# Rezoning Transportation Analysis

Petition Number: 2020-027

Revision Log:	Date	Description
	02-18-2020	First Review

A TYPICAL RESIDENTIAL STREET SECTION (MX ONLY)

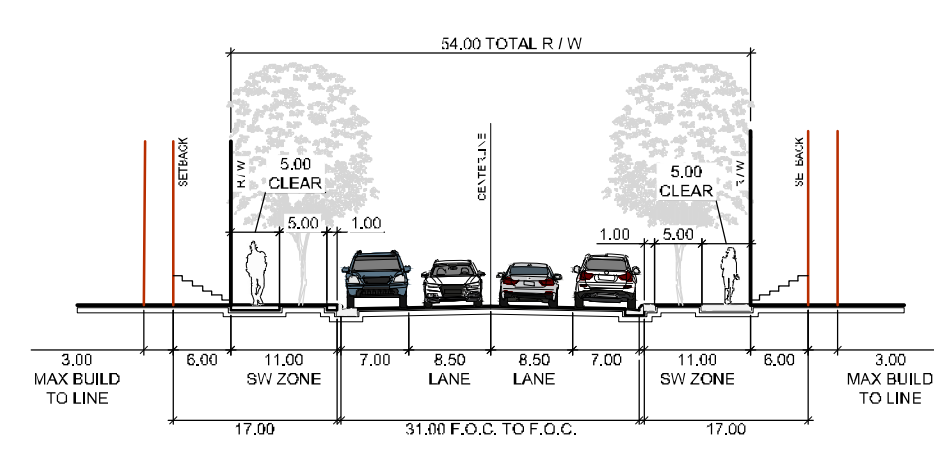
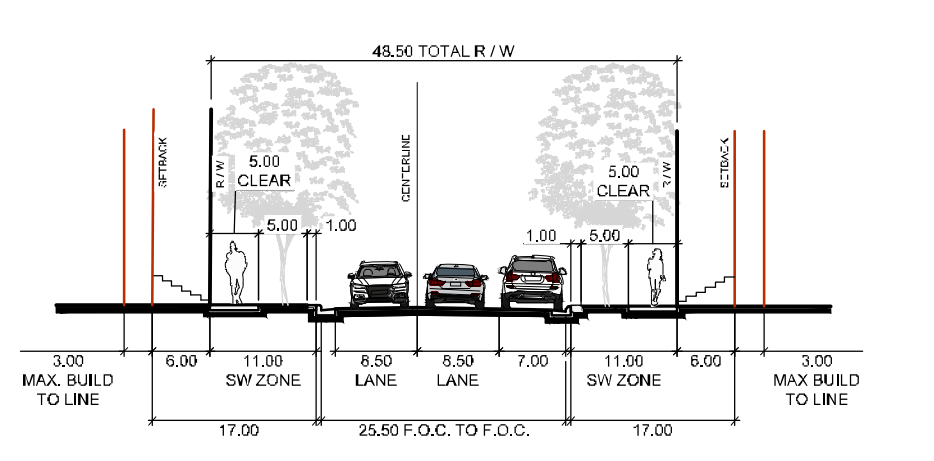
- The petitioner should revise the site plan and conditional note(s) for street typical "A" and "B" to provide 10.5-foot travel lanes to meet the minimum Subdivision ordinance Urban Street Design Typical.

- The petitioner should revise the site plan and conditional note(s) for street typical "A" and "B" to provide an 8-foot wide minimum planting street and 6-foot minimum sidewalk width to meet the minimum ordinance requirements.
